Your Ref: OWPC20162
Our Ref: FP/201/18/PL 03-08-2018
Please ask for:
Richard Castro-Parker

1 No. dwelling.
Mermaid And Playbox Sea Road Felpham

*RE: PROPOSED NEW DWELLING, SITE MERMAID AND PLAYBOX. REF.
FP/201/18/PL*

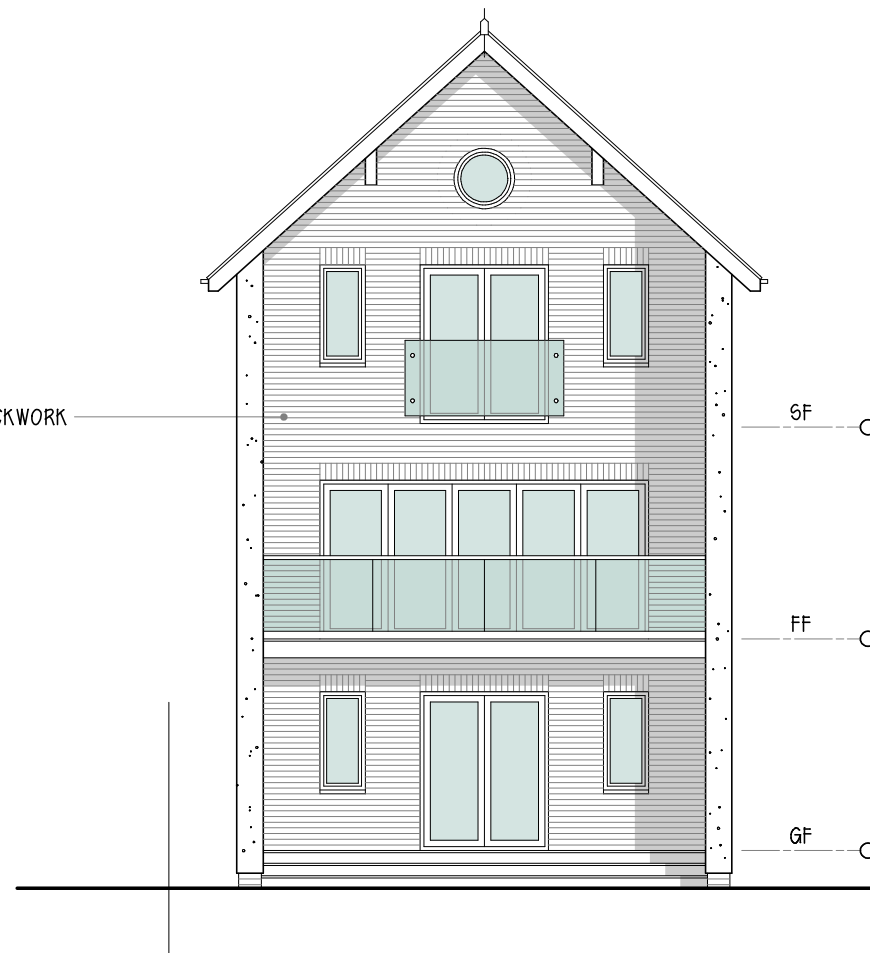
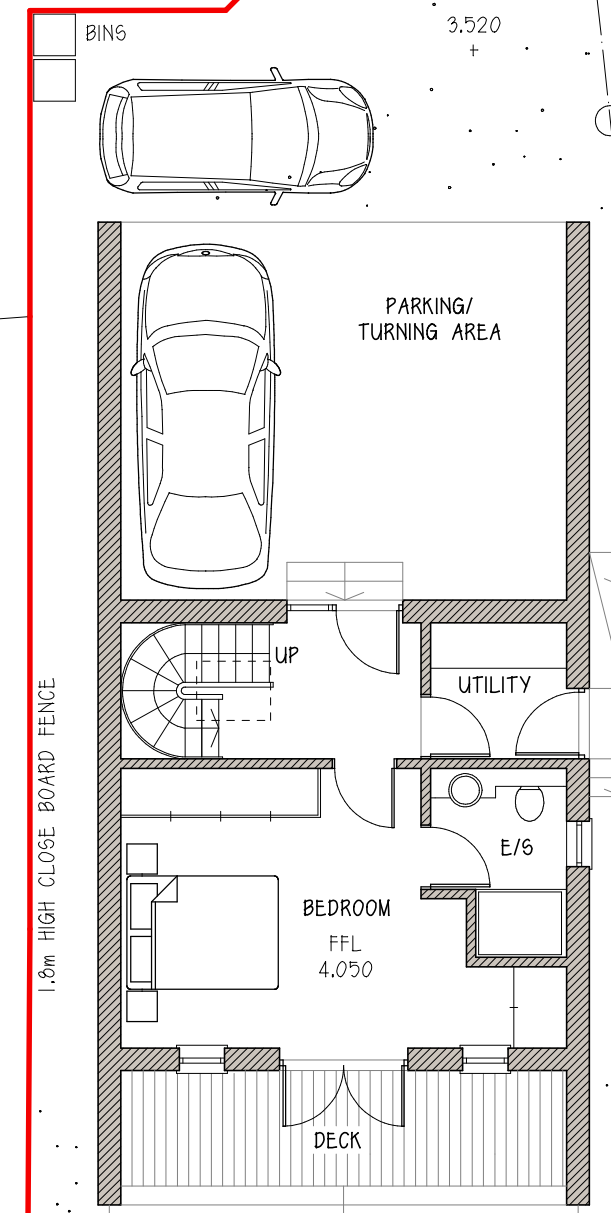
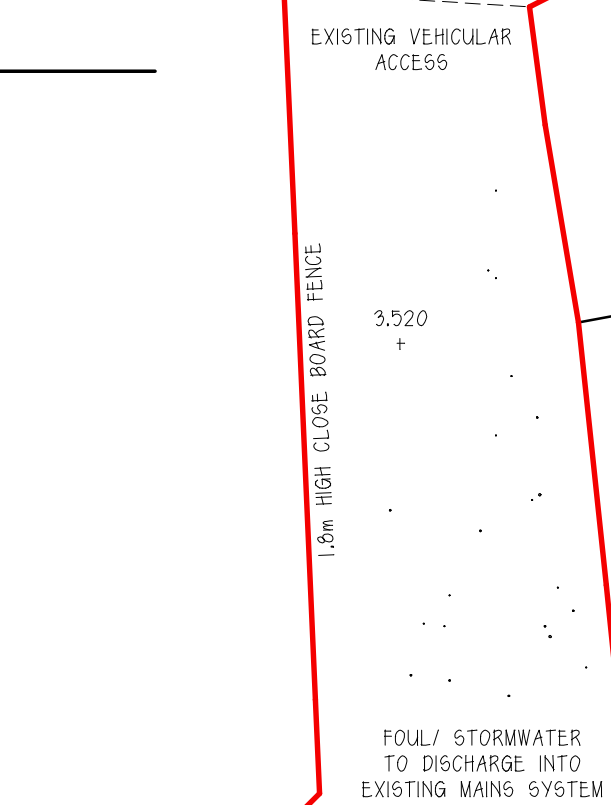
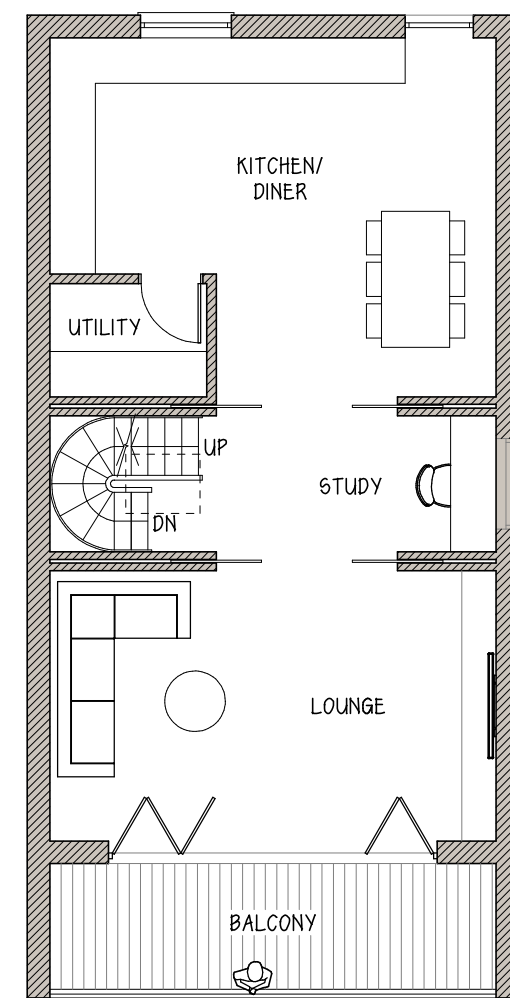
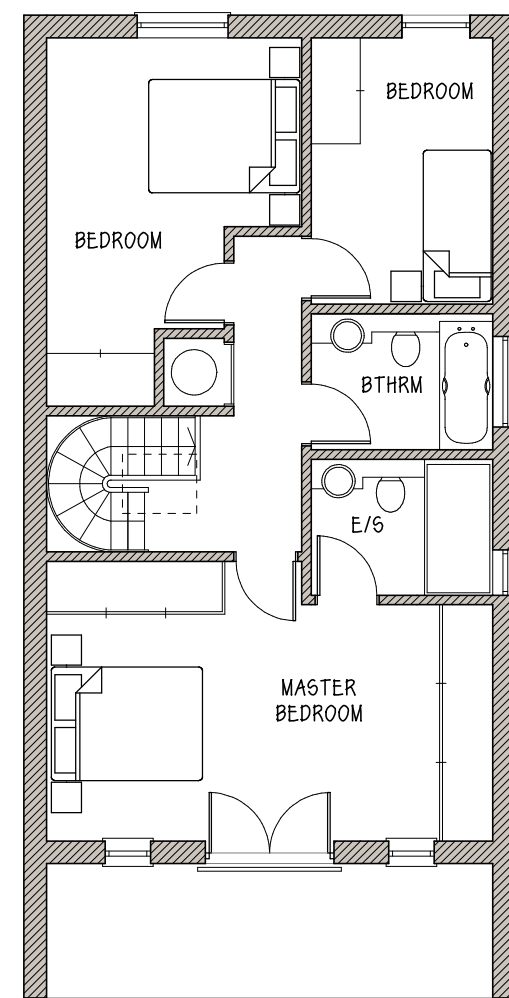
The proposed house is shown with a pitch roof which is not in keeping with the properties within the railway carriage area it is situated. The other properties are 2/3 storey flat roofed buildings which are suitable for the sea front and do not take or obscure others views. The design has the west wall facing towards Longbrook and Bognor as a towering 40 by 30 foot bare wall, which will look dreadful. The whole design is overpowering.

There is living accommodation shown on the ground floor level which has not been allowed by Arun District Council in recent buildings in this area due to the flood levels.

BLOCK PLAN

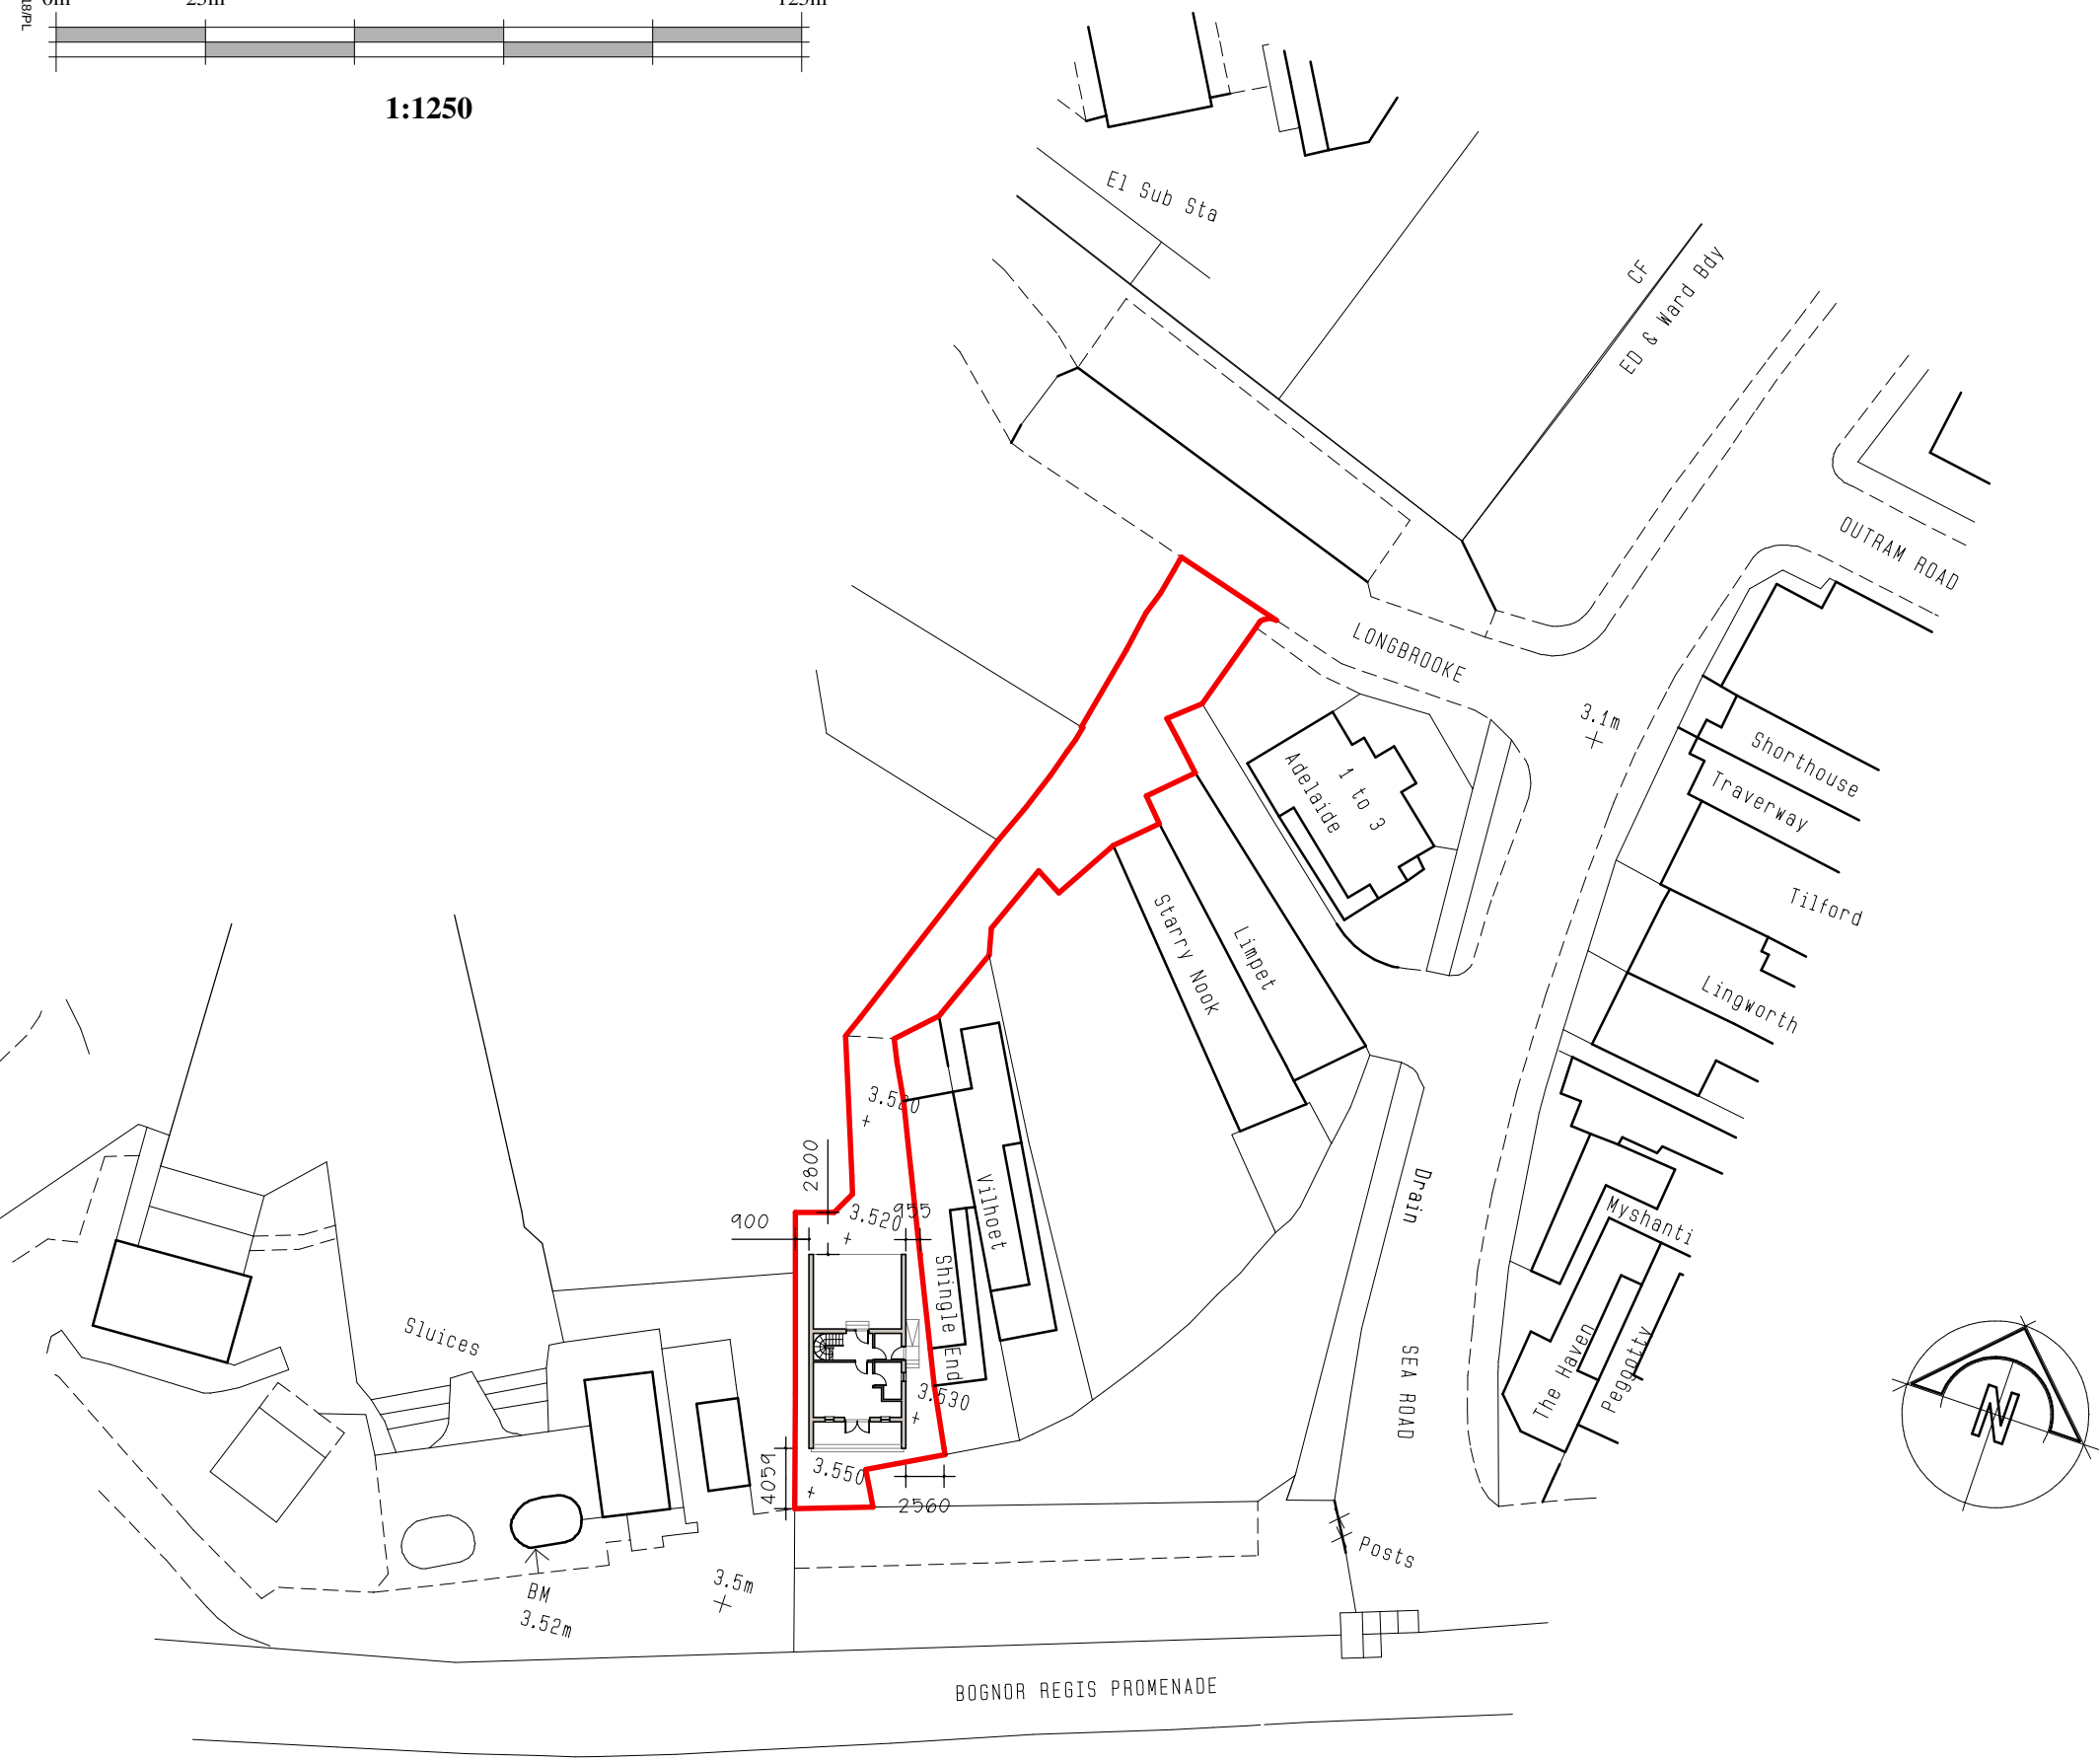
The applicant has shown the portion of land at the front of the proposed house (amenity land) nearest the promenade as being within the development land, this is not the case it belongs to all 9 plots and cannot be taken by one person, so this diminishes the size of the plot.

The overall design does not fit into the immediate area and would detrimentally affect the neighbours. Access and egress are at present not viable as only 4 foot pedestrian area is available to the property.
